**REMOVAL OF OBJECTIONS TO PROPOSED DRAINAGE SCHEME WITHIN PLANNING APPLICATION  
18/00904/F-2 GLEBE FARM, BODDINGTON ROAD, CLAYDON, BANBURY, OX17 1TD.**

# COUNTY COUNCIL'S RESPONSE TO CONSULTATION ON THE FOLLOWING DEVELOPMENT PROPOSAL

**Proposal:** Formation of inland waterways marina with ancillary facilities building, car parking, access and associated landscaping including the construction of a new lake

Drwg Title: **PROPOSED HIGHWAYS ACCESS & VISIBILITY SPLAY PLAN**

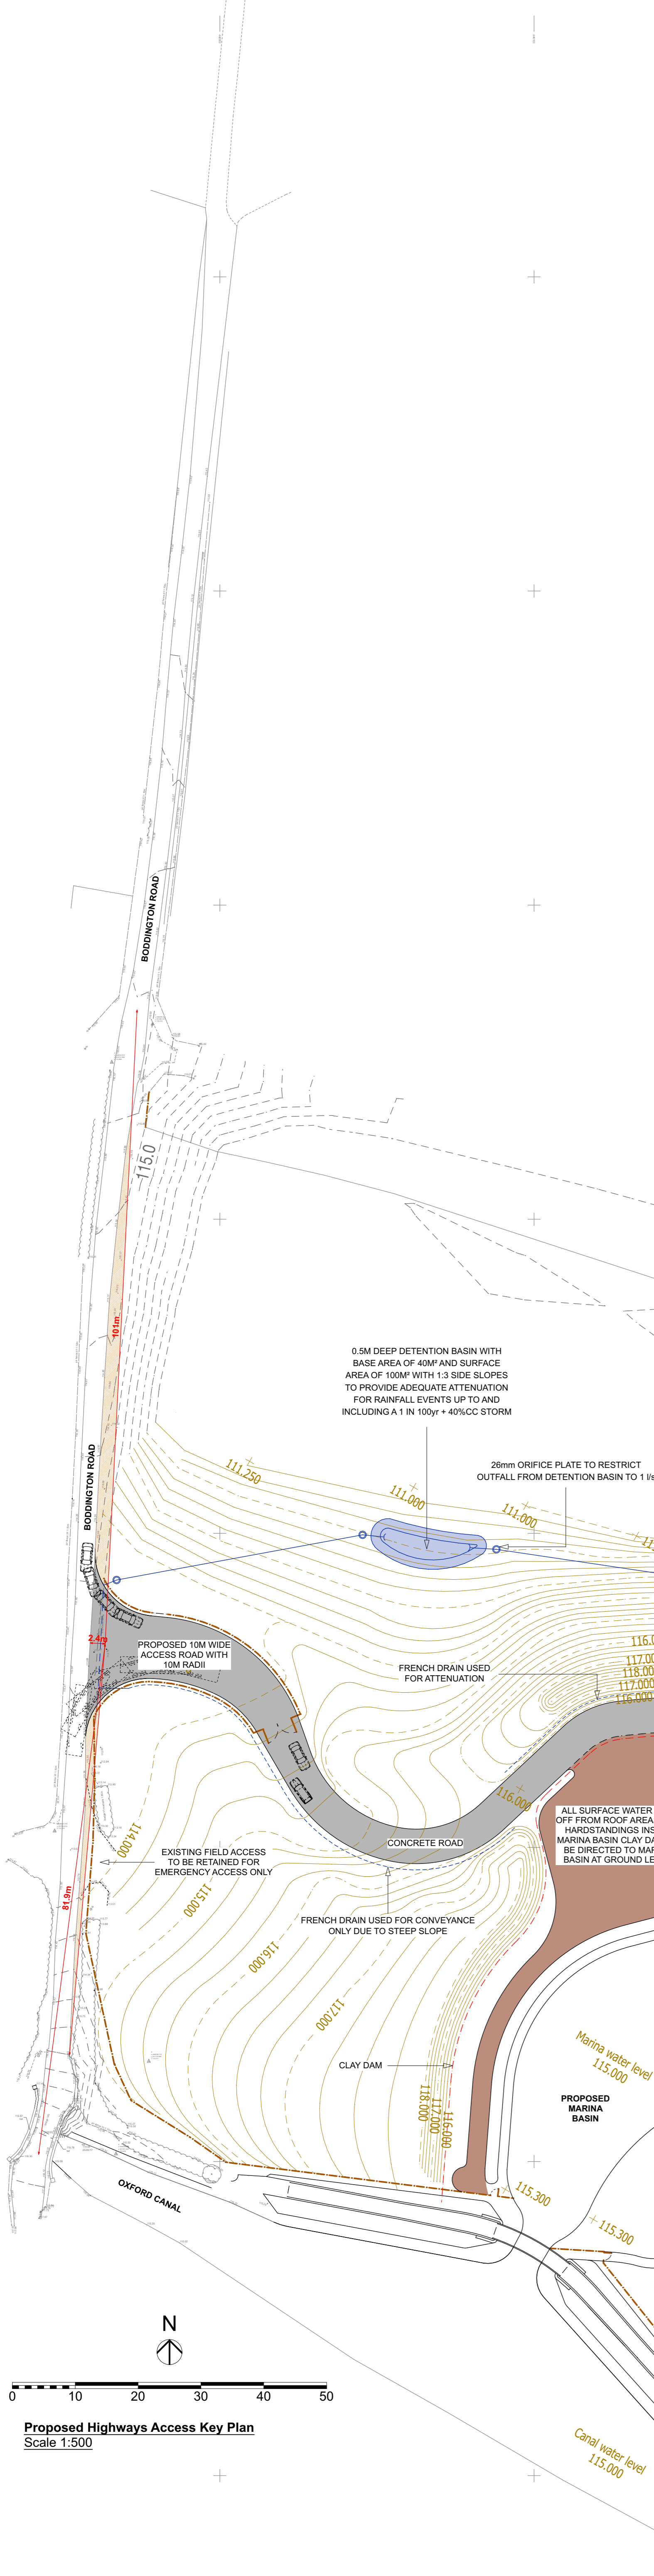
From a recent site visit, I am not convinced that the required visibility splays are achievable for a national speed limit road. It might be the case that vegetation will need to be significantly cut back to allow for the required splays to be achieved. I however agree that due to the physical constraints of Boddington Road such as the hump back bridge south of the site and the carriageway being single track traffic speeds are generally low.

PROPOSED EASTERN DETENTION BASIN TYPICAL SECTION
Scale 1:100

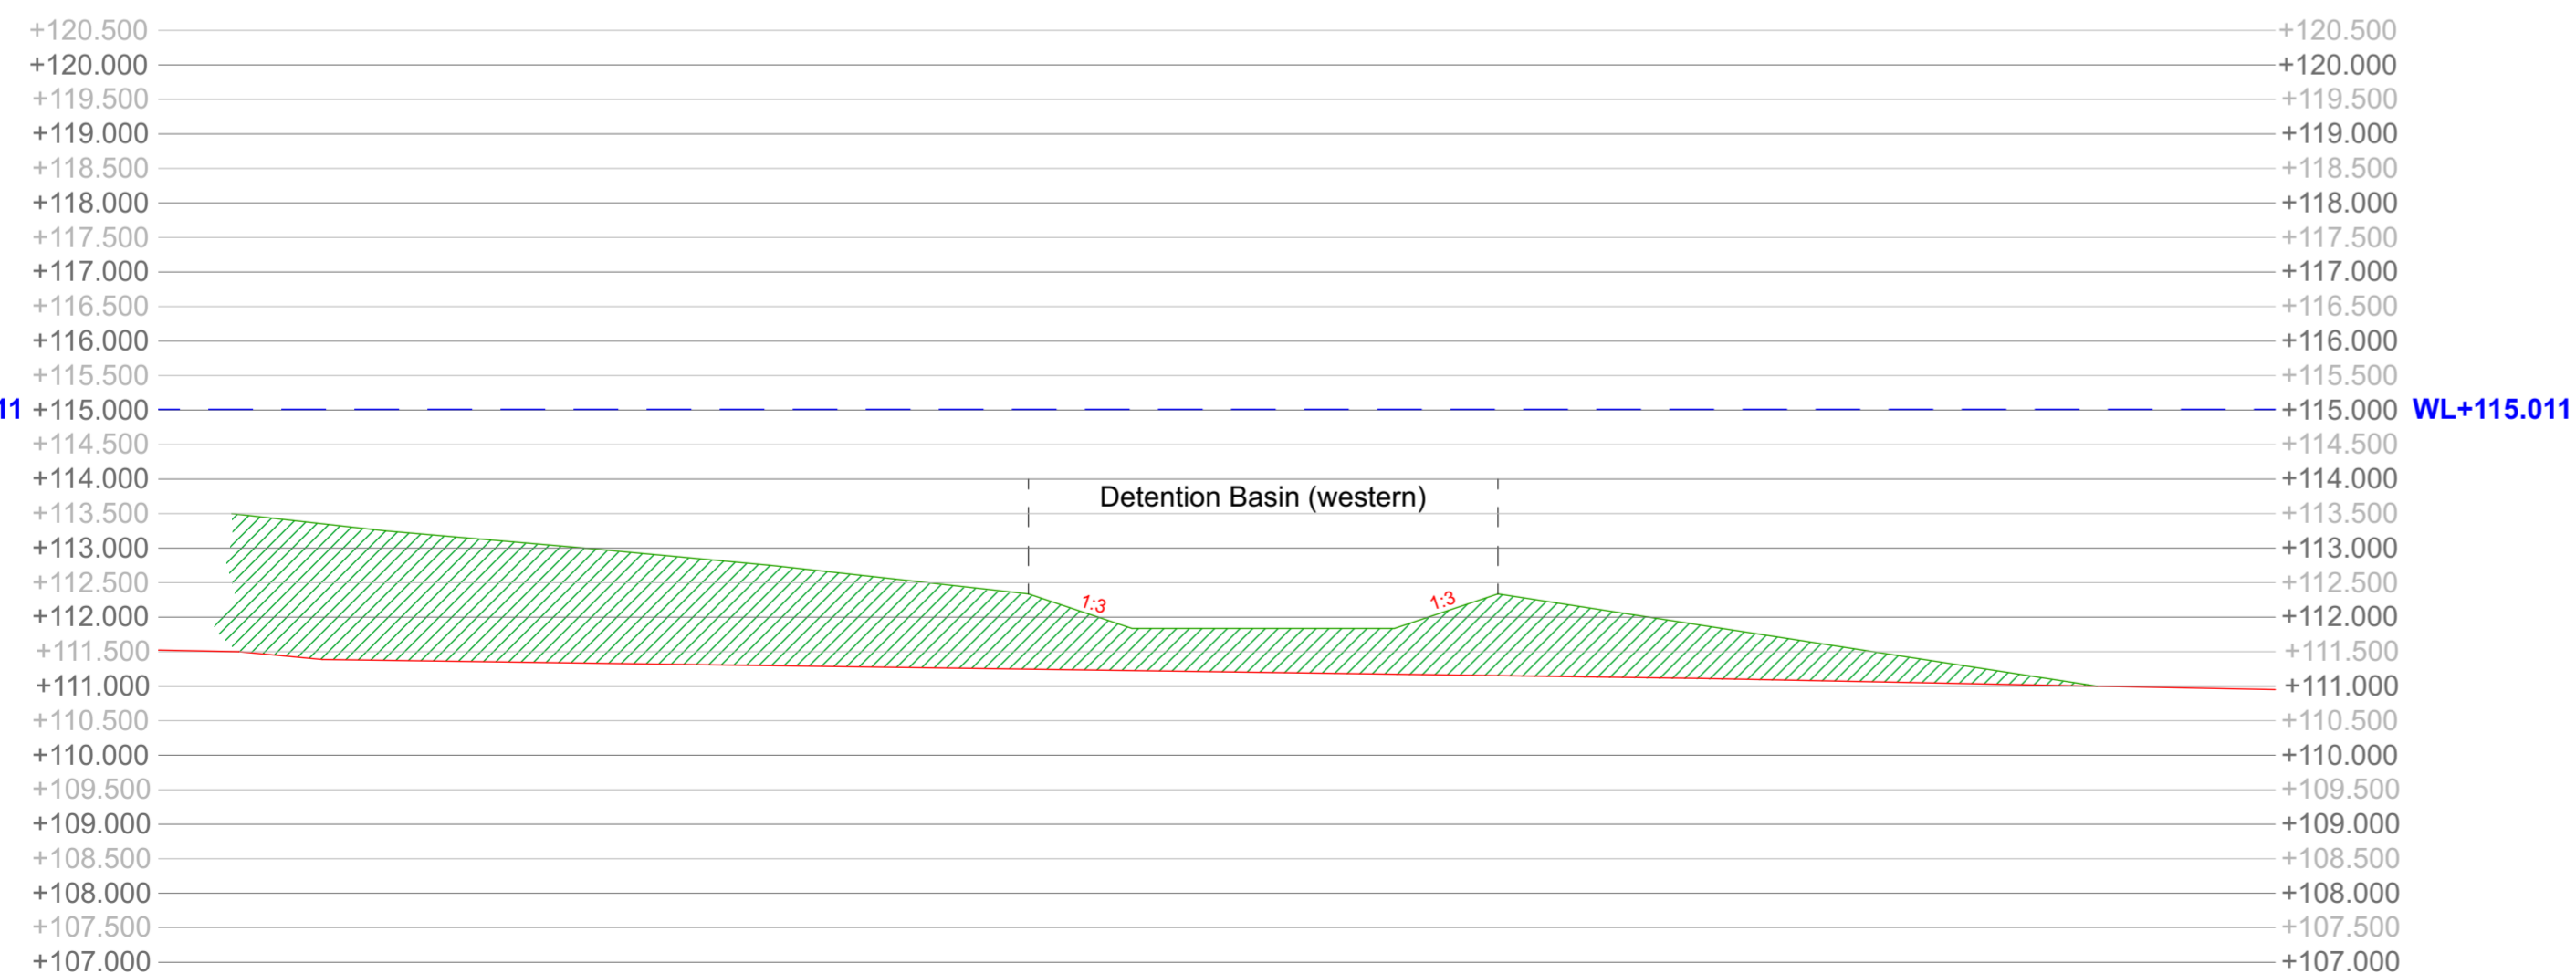
*A gravel surface as proposed for the access and parking areas is inappropriate as it looks like it will be in constant use. The proposals will need to ensure that all water within the areas that are being used will be collected and treated appropriately as well as being appropriately managed to not increase flood risk elsewhere.*

*Although permeable surfaces are being proposed, they will need to provide storage as well either within the permeable system or a separate attenuation system. This does need to be quantified for the whole site and will require a controlled outfall to an existing watercourse or surface water drainage system if infiltration is not feasible.*

A gravel surface for these areas will be appropriate as they are not to be heavily used and the site developer is aware of the likely maintenance requirements. It is now proposed that runoff from these areas will be directed to filter drains and a detention basin before outfalling to the lake on the eastern side of the site as mentioned above. This has been discussed in Section 6 paragraphs 6.8 to 6.24. As such flood risk will not be increased

It is now proposed that runoff from these areas will be directed to filter drains and a detention basin before outfalling to the lake on the eastern side of the site as mentioned above. Other than the access roads and parking areas within the marina basin which as previously mentioned will outfall to the marina. This information is discussed in the FRA Section 6 paragraphs 6.8 to 6.24.
